Consultation Response from KC, Conservation & Design
2023/91527 31, Chapel Hill, Linthwaite, Huddersfield, HD7 5NJ
Listed Building Consent for change of use and alterations to former church (B8-storage) to 9 residential units (C3) and formation of car park(within a Conservation Area)
Date Responded: 10/6/25 Responding Officer: S Campbell Responding Ref:

Drawing:  
 Proposed  
 Site Sections

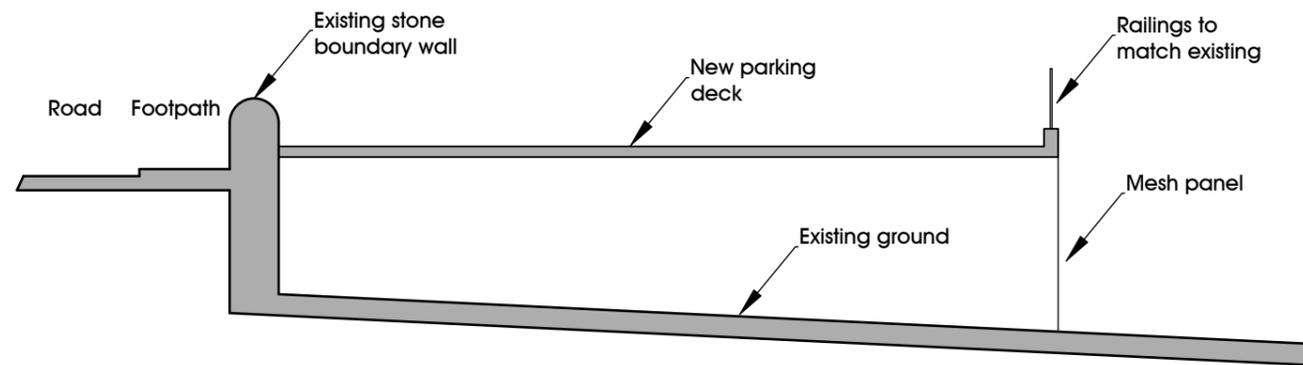
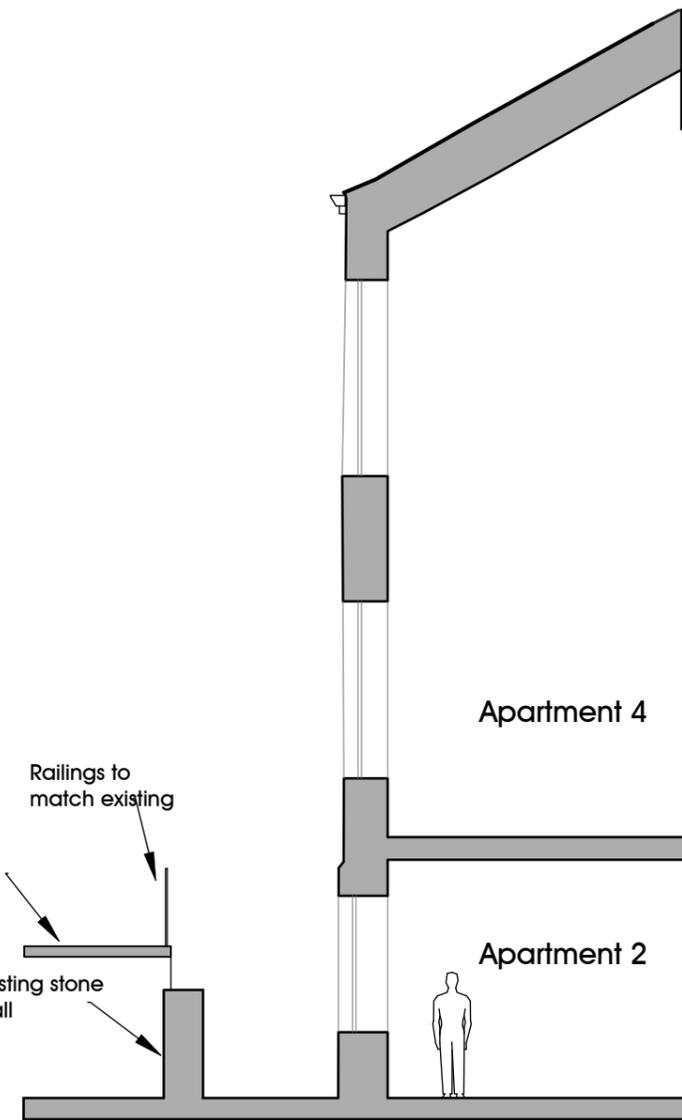
Conservation Team notes that the new raised parking deck supported by steelwork and with a concrete finish, which will be raised by up to 2.5m above the existing garden level. The raising is necessary to create a level surface so the ramp won't be too steep a gradient down into the car park. At its northern end it will come above the top of the small boundary wall adjacent to the path around the southern end of the building, and will therefore obscure the lower ground floor of the building when viewed from the road. It is considered that the car park will cause less than substantial harm to the setting of the Listed Building which could be outweighed by the public benefit of securing a viable use for the building. It appears that it is considered to be necessary if the building is to be reused as it is needed for off-street parking.

1. Retain or rebuild a similar stone boundary wall around the edge of the site and this structure (allowing for the entry point/ramp).
2. Use a buff coloured concrete finish, or something that would blend better with the existing Listed Building.

PROPOSED WEST ELEVATION 1:100

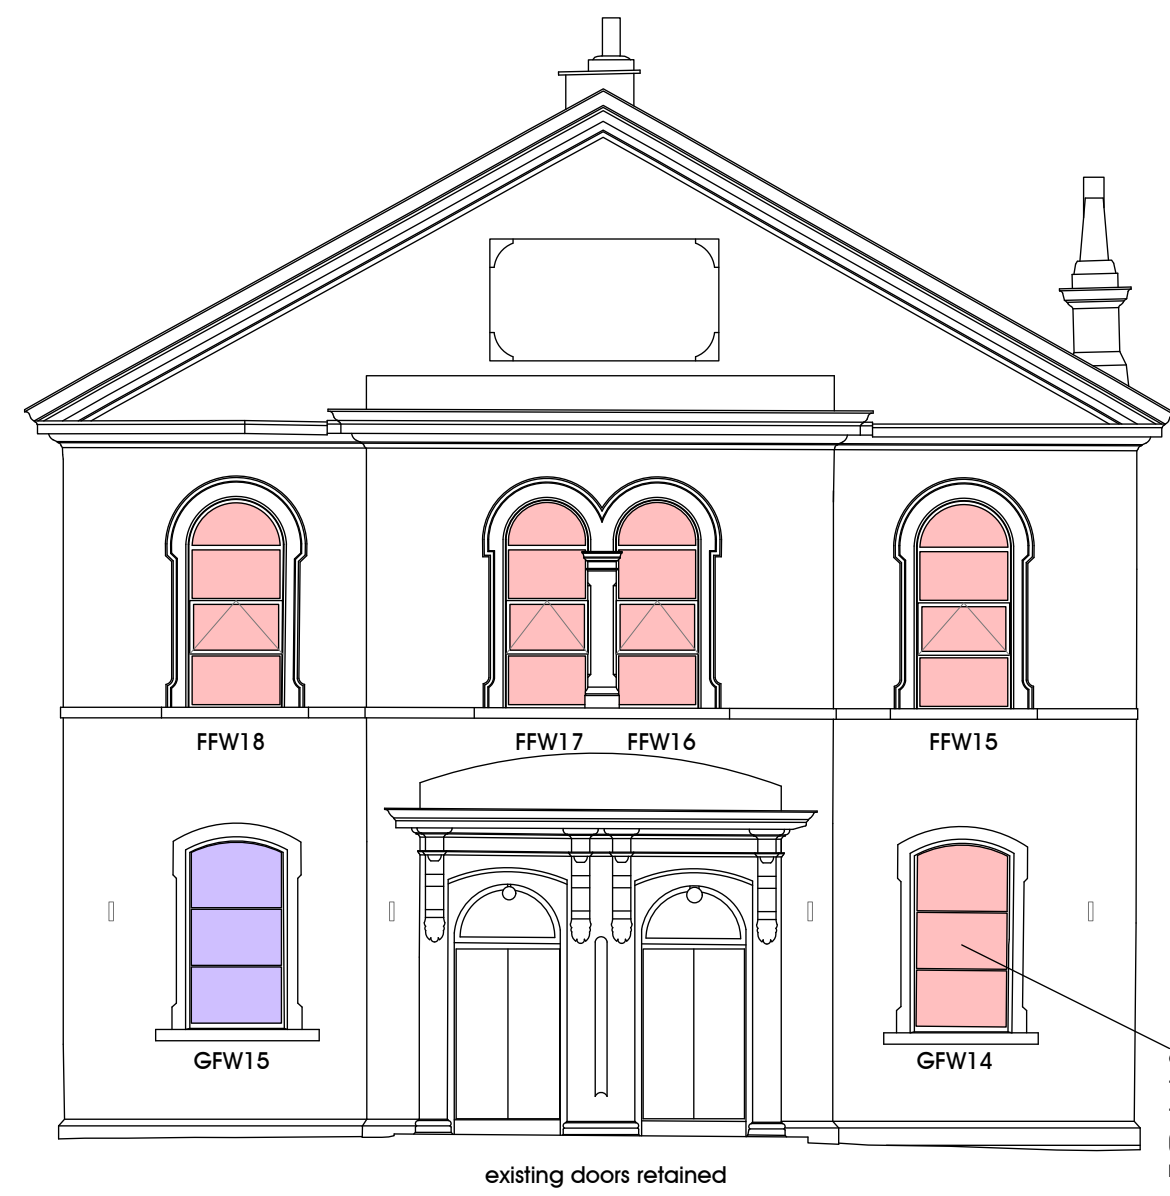
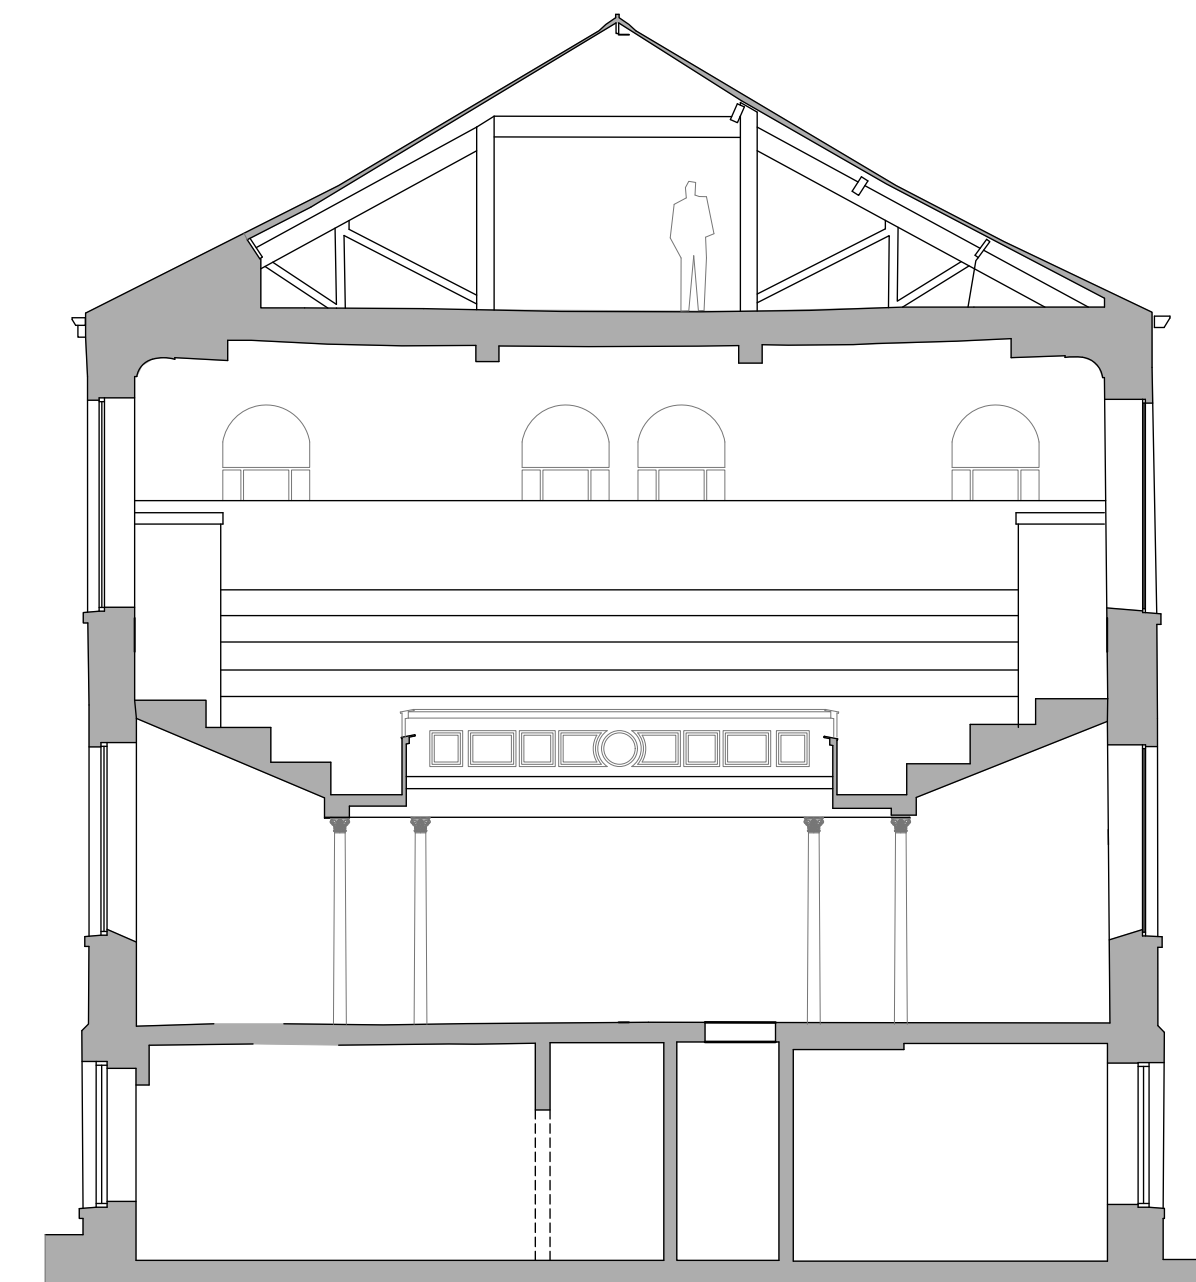
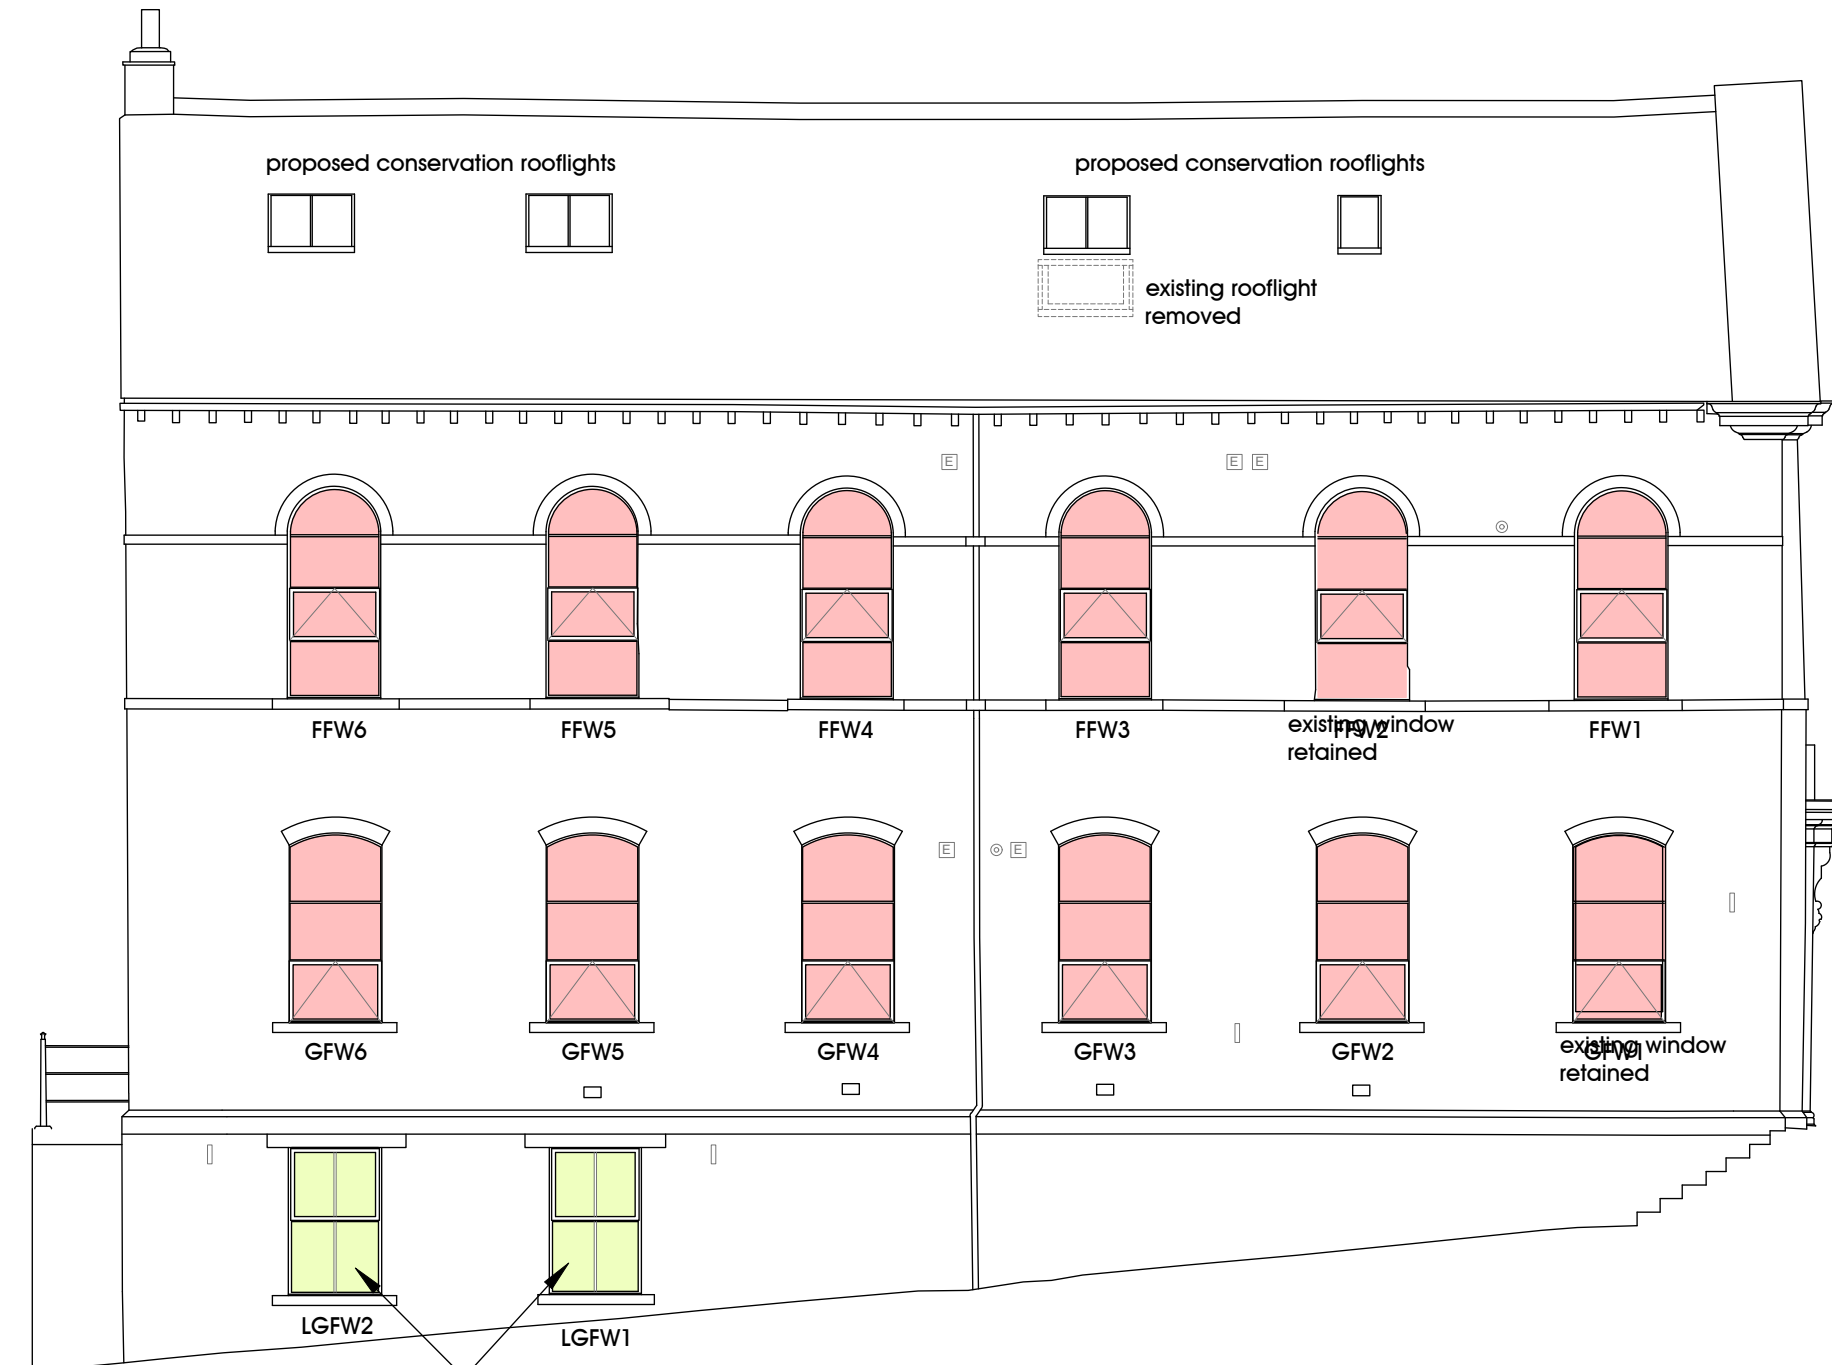
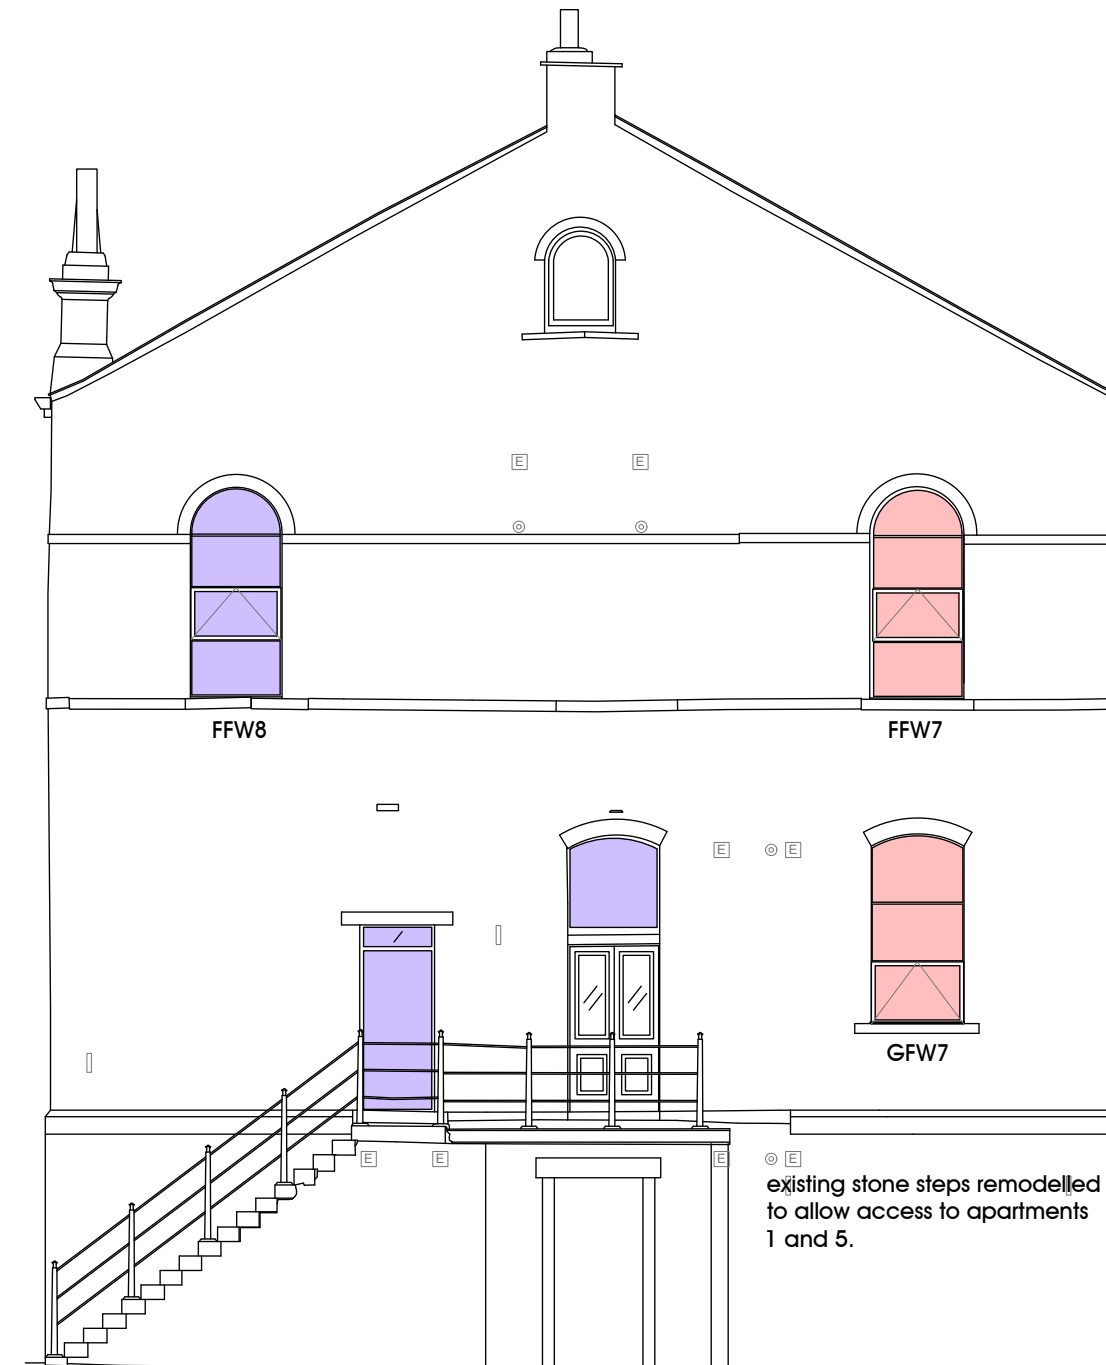
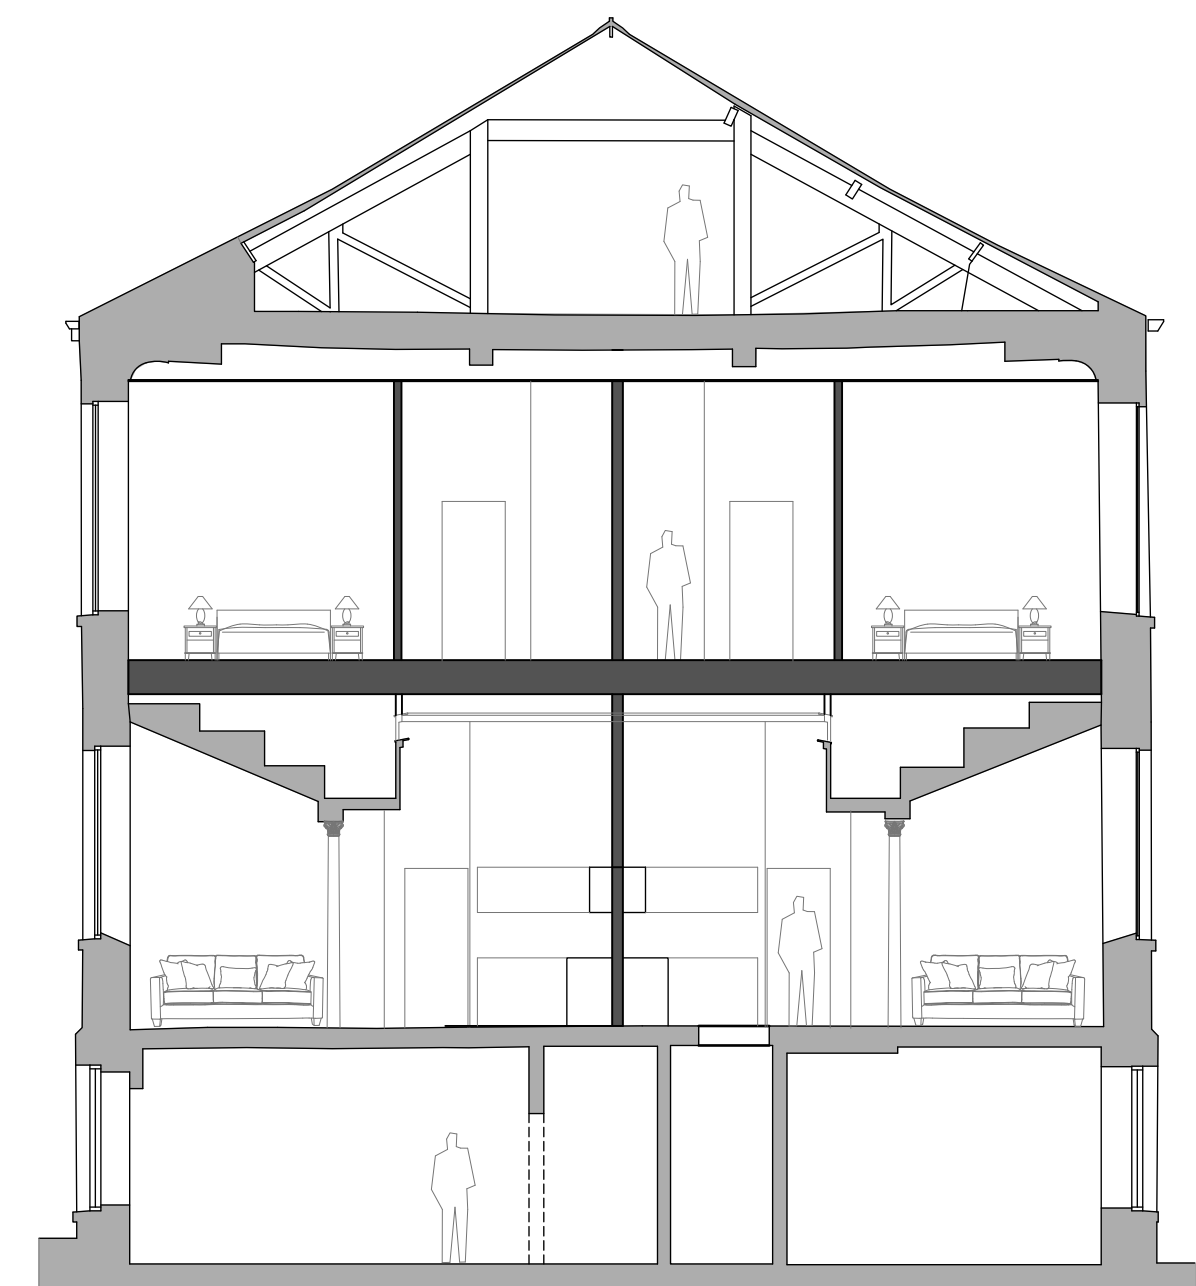
Regarding the window alterations, the applicant has provided amended details which are generally acceptable but there is some discrepancy regarding the use of timber or metal.

I note that there are proposals for metal frames for most of the windows and encapsulation is proposed for treatment of any original or early stained or coloured glass. This is considered acceptable provided that the outer frames use a metal framework as the agent has confirmed can be provided.

It would still be preferred if the former caretakers' flat could be timber windows, but we could allow for slimlite double glazing with sliding sash using spiral balance, rather than traditional sash but provided the windows open up and down, not outward opening. If this is considered to be less prominent then I consider that the less than substantial harm in changing the material would result in public benefits of bringing a new viable use to this listed building.

It would be preferred that the metal windows in the rest of the building be inward opening but the agent states that they cannot provide water tightness so for this reasons we would accept outward opening on the limited openers as suggested by submission of details.

It is recommended that a Condition should require further details to be submitted for window details, sections, method of opening and a sample of the encapsulation prior to production of all the windows.
